From: Dunderdale, Chris <Chris.Dunderdale@lancashire.gov.uk>
Sent: 17 March 2016 11:58
To: planning
Subject: RE: Consultation on Planning Application 3/2016/0146 Old Row Whalley Road Barrow BB7 9AZ

The application is for: Outline application with all matters reserved for residential development of 23 dwellings , with access, parking and associated landscaping following demolition of Nos.23 25 Old Row

drawing: **PROPOSED SITE LAYOUT**

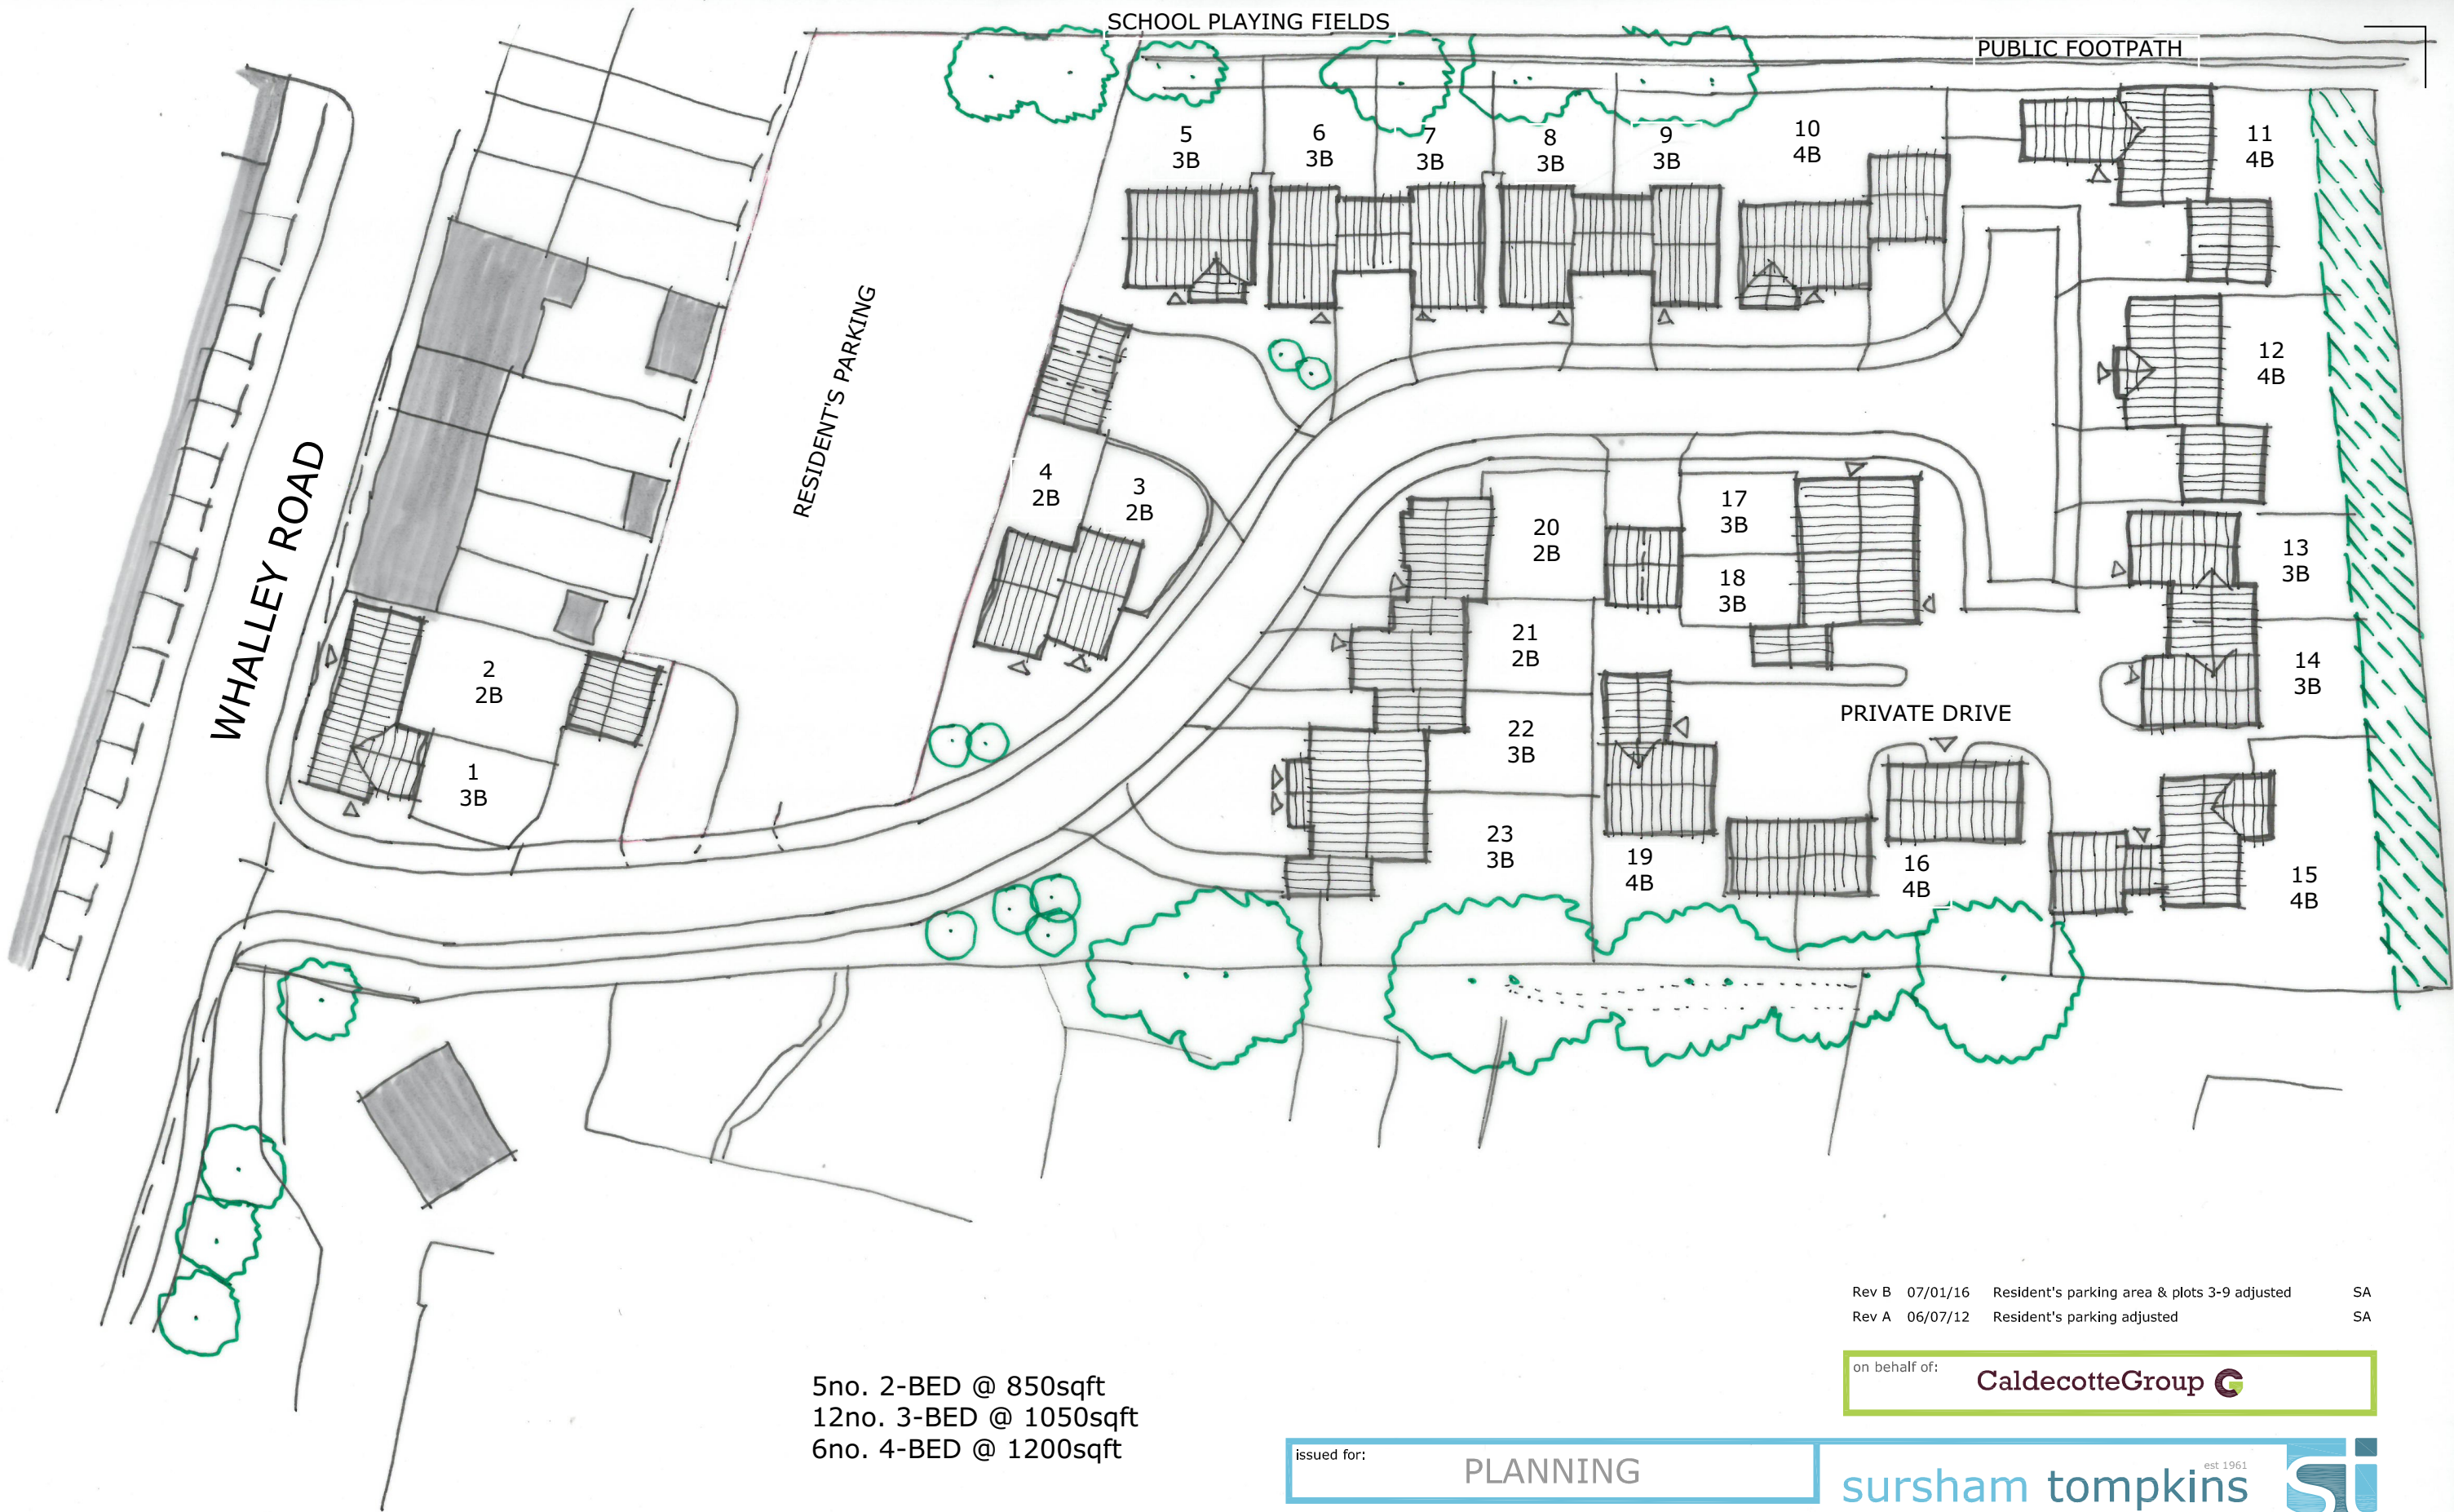
Before we are able to provide a substantive response to this consultation, we would require clarification over the proposed method of surface water disposal for the proposed development. We would also require an indicative site drainage plan that shows the location of any proposed sustainable drainage systems and proposed outfall locations. For consistency, the application form and flood risk assessment should be amended accordingly.

- d) **Insufficient information submitted – hydraulic calculations:** Section 4.5 of the flood risk assessment indicates that the hydraulic calculations provided (ie. discharges rates and on site storage requirements) are based on an impermeable area (hardstanding) of 0.57ha. This accounts for roughly half of the proposed development site. Whilst it is recognised that the remainder of the site is proposed to be comprised of soft landscaped areas, section 4.2 of the FRA indicates that it is unlikely that infiltration would be possible due to the ground characteristics. This would suggest therefore, that 100% of the proposed site would in fact be impermeable. As a result, the applicant has failed to account for roughly half of the site in their hydraulic calculations.

- e) **Insufficient information submitted – detailed location and layout plans:** The applicant does not appear to have submitted any plans showing any existing surface water flow routes, drains, sewers and watercourses.

**LAND OFF WHALLEY ROAD
BARROW
drawing:
LOCATION PLAN**

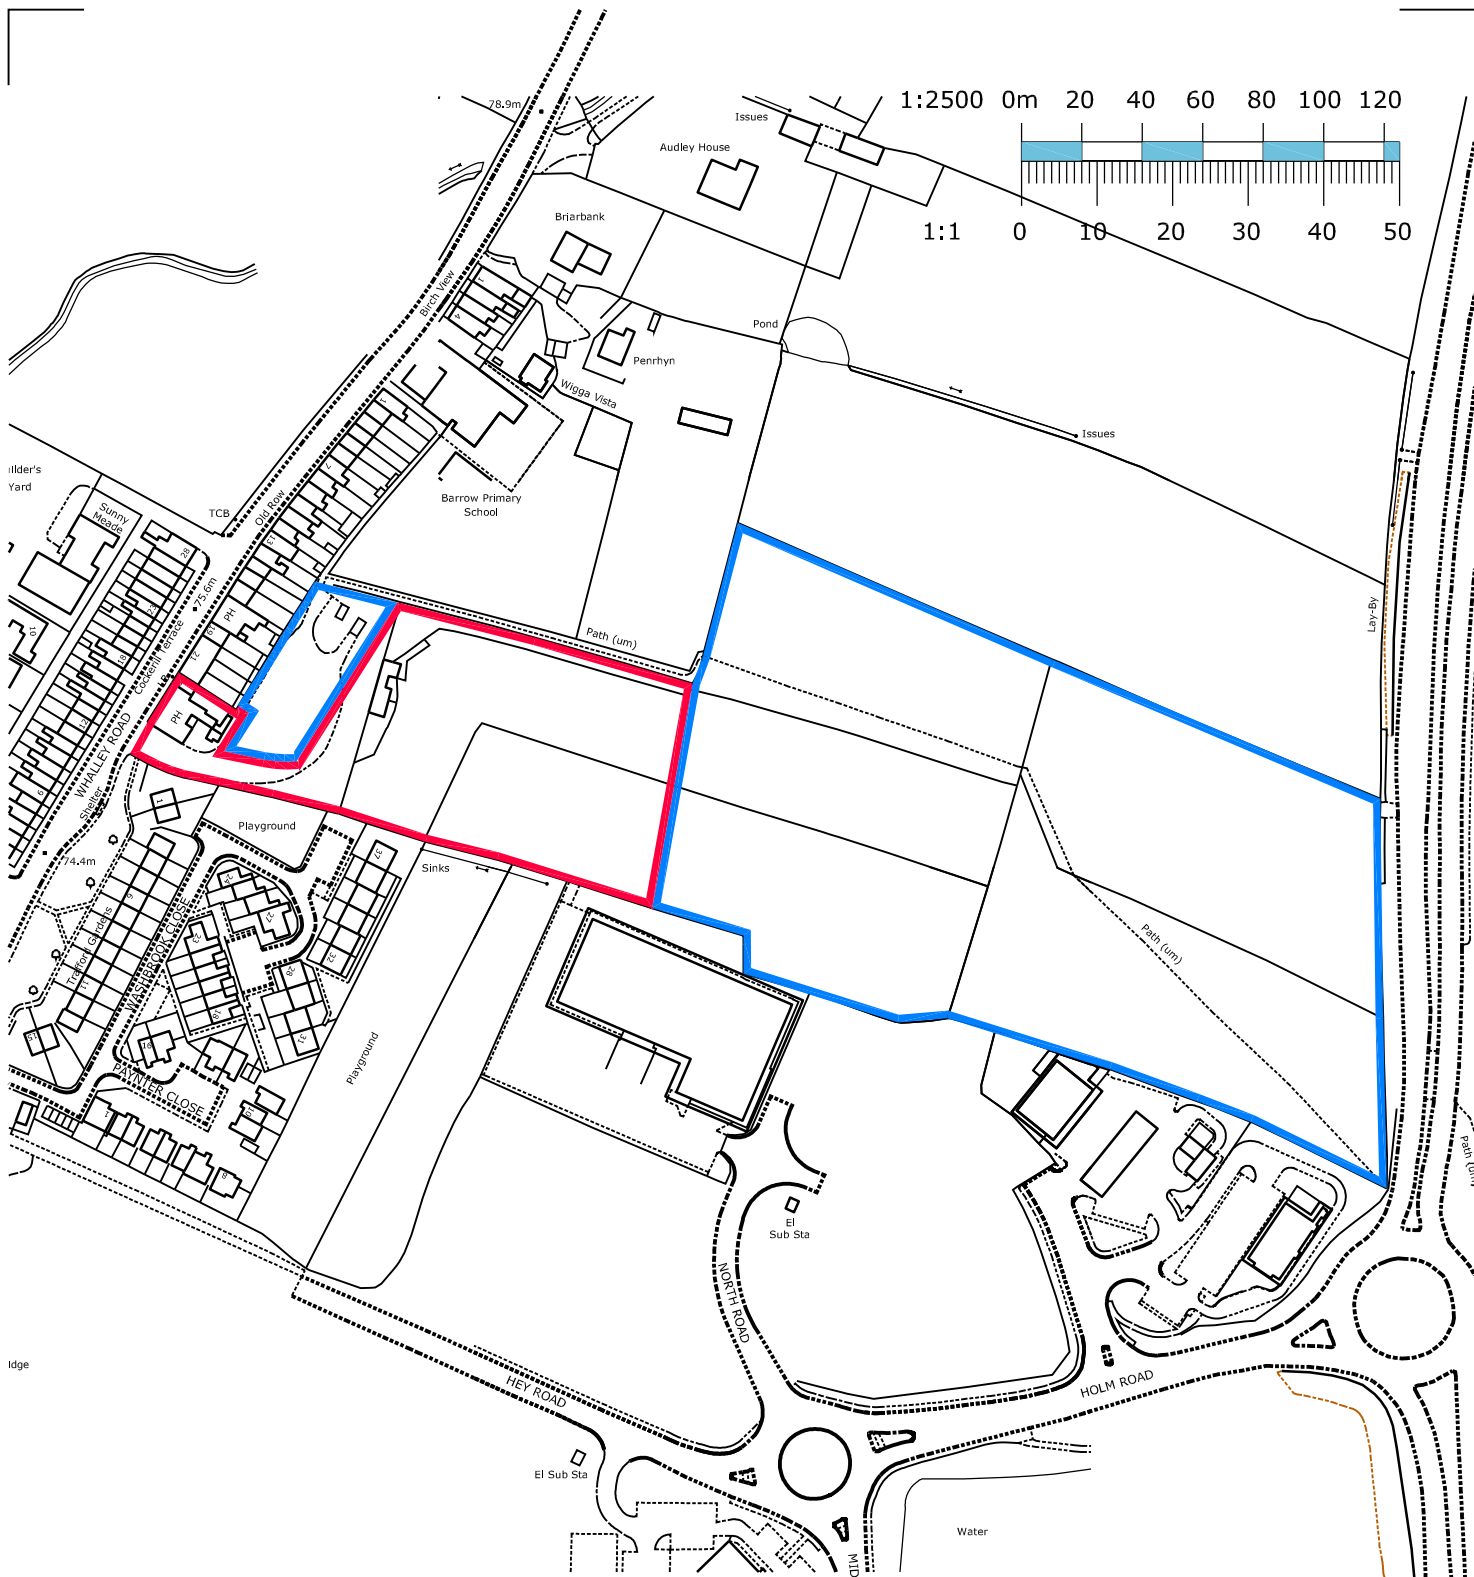
- a) **Discrepancies over the size of the proposed development:** The application form submitted by the applicant indicates that the site is 00.96ha in size, however, sections 1.2 and 2.2 of the flood risk assessment (Ref: '46648', Dated: 'February 2016'; By: 'AAH planning consultants') indicate that the site is actually in excess of 1ha (1.16ha). We are concerned by this as the size of the site can significantly affect whether or not the proposal complies with national planning policy.

Before we are able to provide a substantive response to this consultation, we would require clarification over the actual size of the proposed development. For consistency, the application form and flood risk assessment should be amended accordingly. **Please note that we would also expect that any amendments should include an account of the recent floods (Nov 2015 – Feb 2016) and whether the site was affected.**
